Subject: RE: BN/50/20/PL (Condition 13) - Pre-commencement site meeting (Tree Protection Measures)

Mark Warwick
Tree Officer, Greenspace Team

LLD1544-ARB-DWG-002

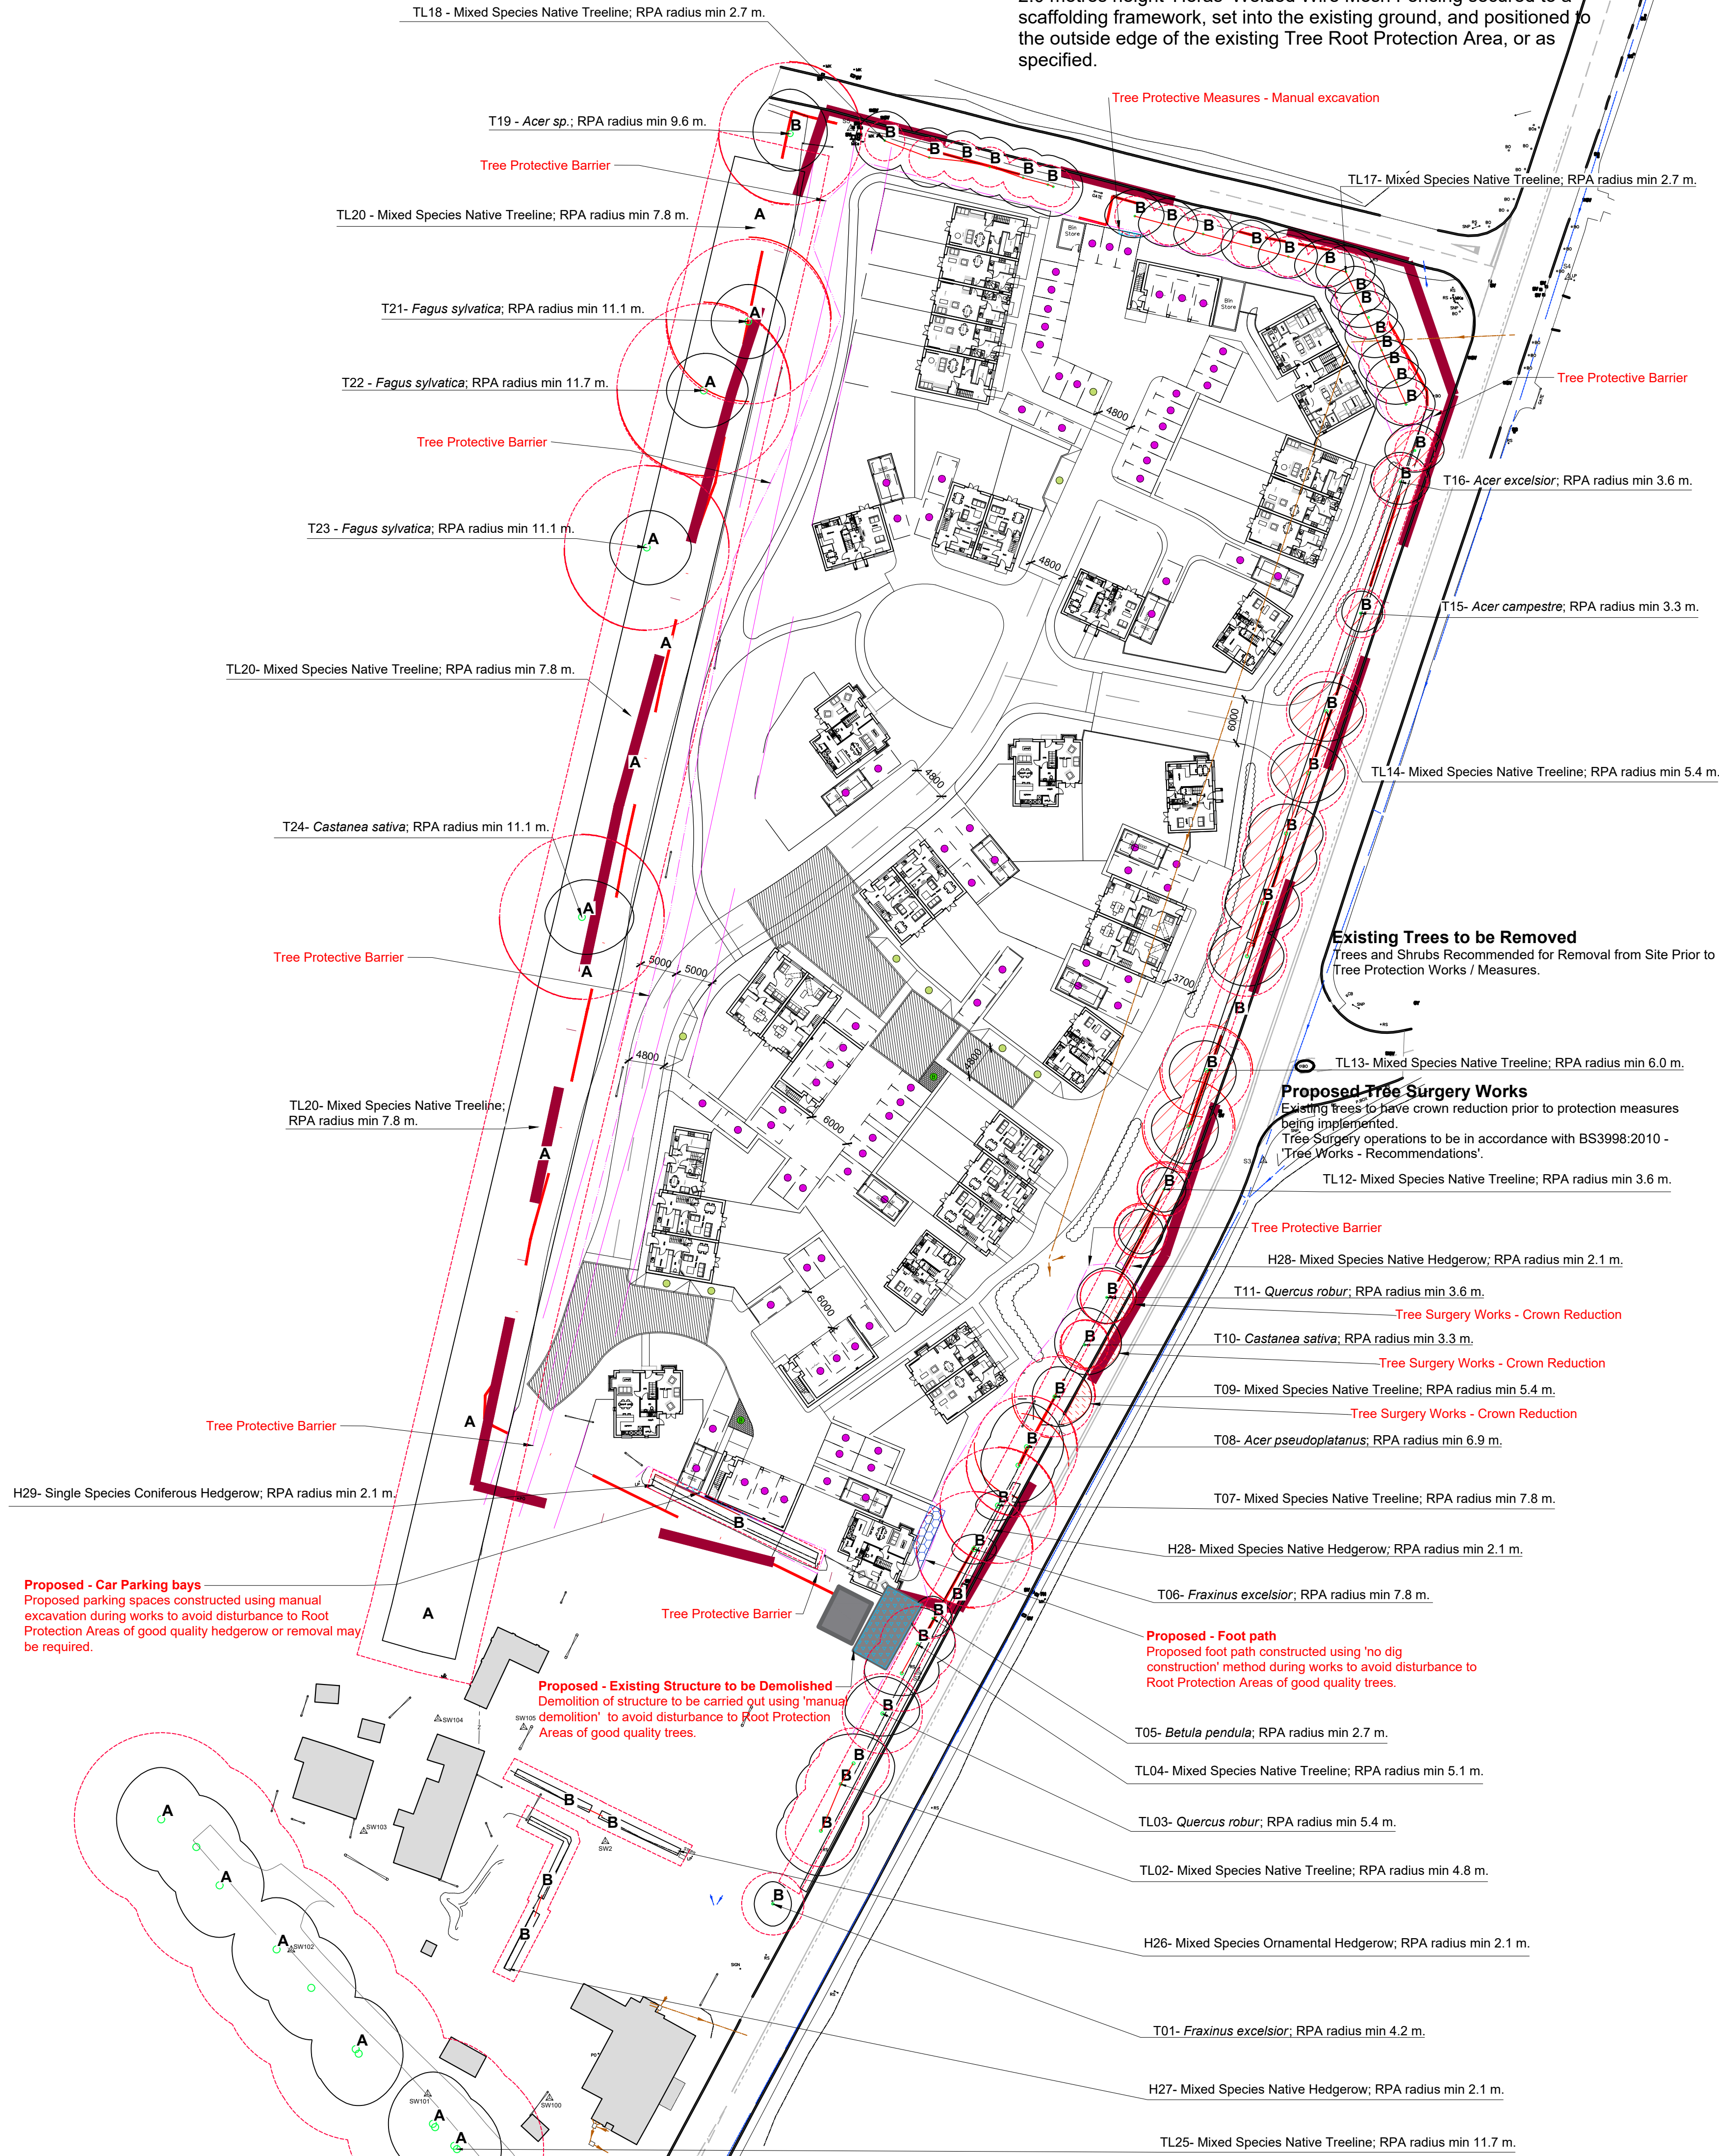
I can report that the vast majority of Tree Protection Fencing is correctly located and installed 'fit for purpose', although there are a number of significant anomalies which will need to be resolved prior to commencement and to ensure adherence with the approved Arboricultural Impact Assessment and Method Statement. Described as follows:

- Fence line is open at NW corner of site.
- Fence line is open at existing 5-bar gated access from Fontwell Avenue.
- All-weather notices attached to HERAS panels are scarce and their message lacks authority, appearing more to be an advertisement for the tree work contractor who provided them. The following important wording is missing – '*Construction Exclusion Zone – NO ACCESS*'.
- There are no day-glo ribbons attached to the top of the barrier, to ensure the fencing is clearly visible during the works.

Please can you confirm in writing and by providing photographic evidence, as soon as those refinements have been made.
